Marge Schmuckal - 66 Parsons Road application

Subject: 66 Parsons Road application

139-D-025 #2013-01617

Office
1st Floor

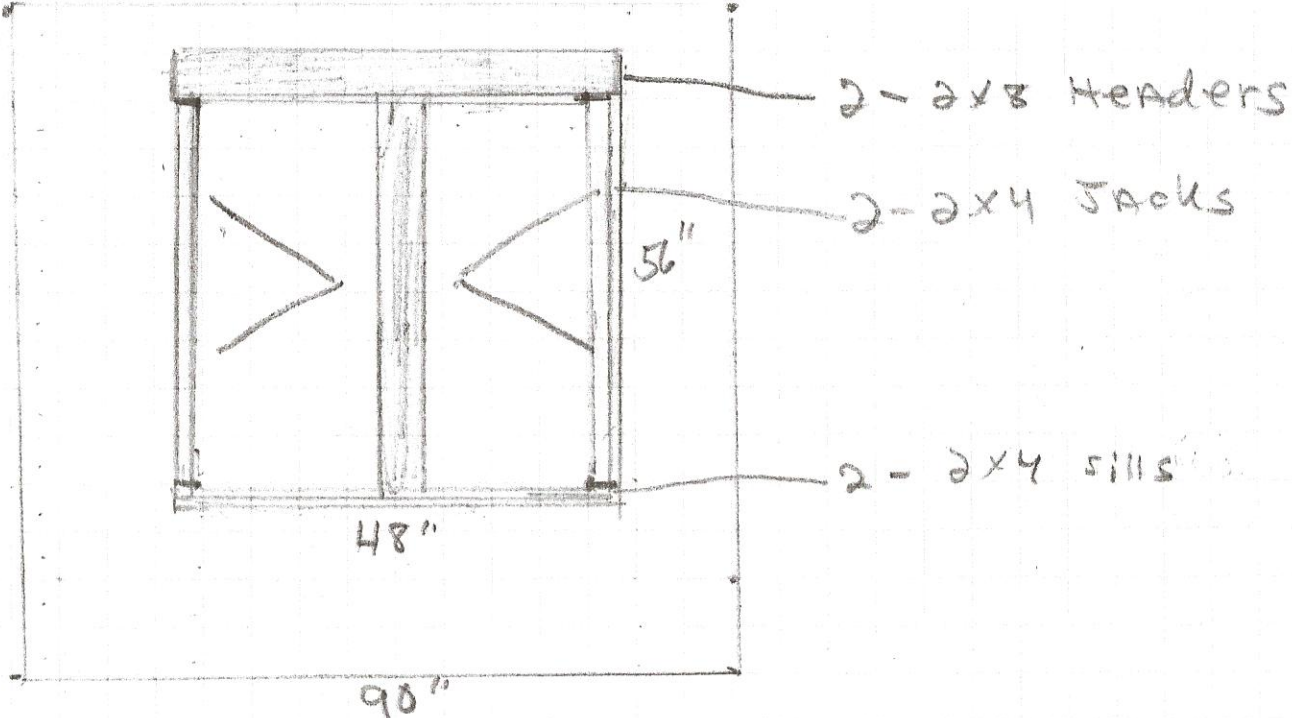
I am reviewing your application to install windows in an office at 66 Parsons Road. Can you explain the office use to me? I see no application for an "office" use at this residence. I can not sign off on this application without further explanation.
